**Addendum Planning Information**  
**546 Stonefield Way, Ruislip**

**Planning App Ref: 62972/APP/2024/1012**

Date: 11<sup>th</sup> June 2024

PROPOSED ELEVATIONS

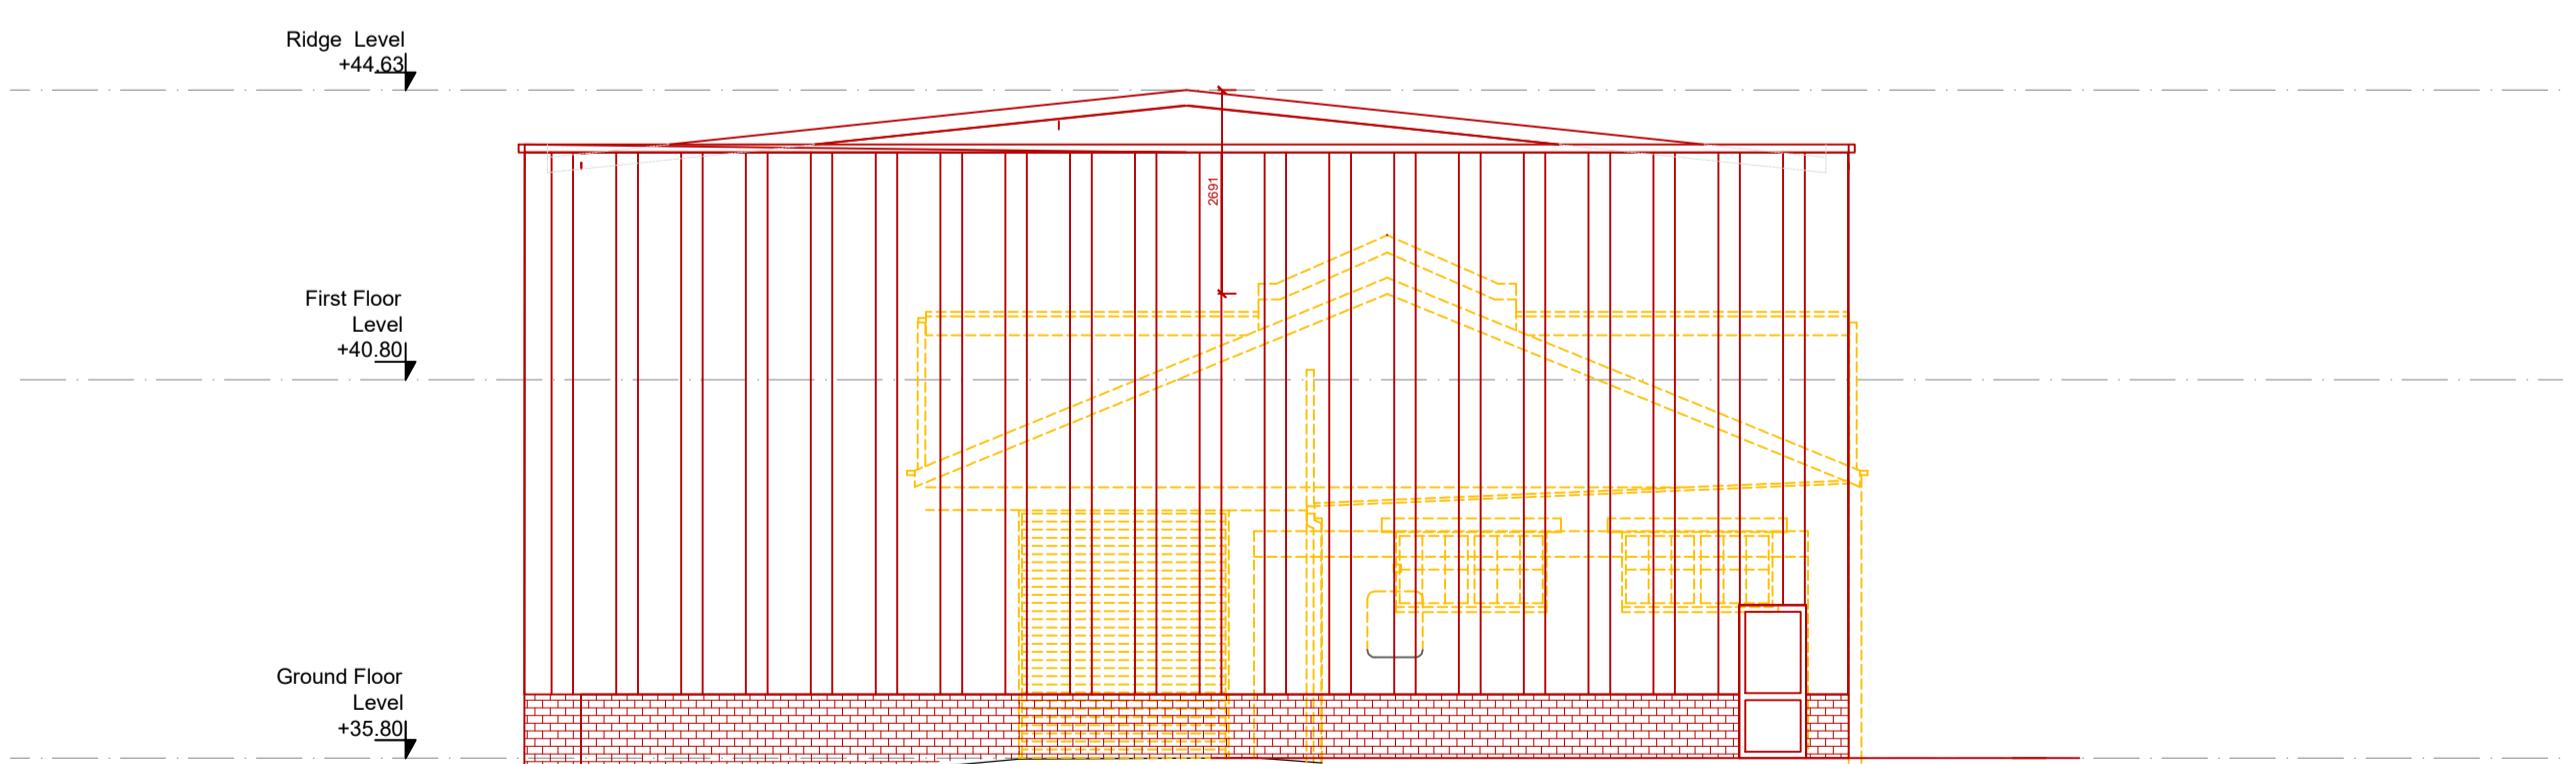
- Why the extent of development is needed (i.e. the height and plot coverage is significant especially in comparison to the main building); and

- What materials are proposed (they do not appear to harmonise with the material palette currently used on site).

*Height of building proposed matches adjacent buildings. Site area proposed to built upon is not utilised for anything other than storage containers – which would then be subsumed in new extension.*

*Standard Euroclad or similar cladding and roof system similar to adjacent other warehouse buildings. Client is happy to reclad existing too to match.*
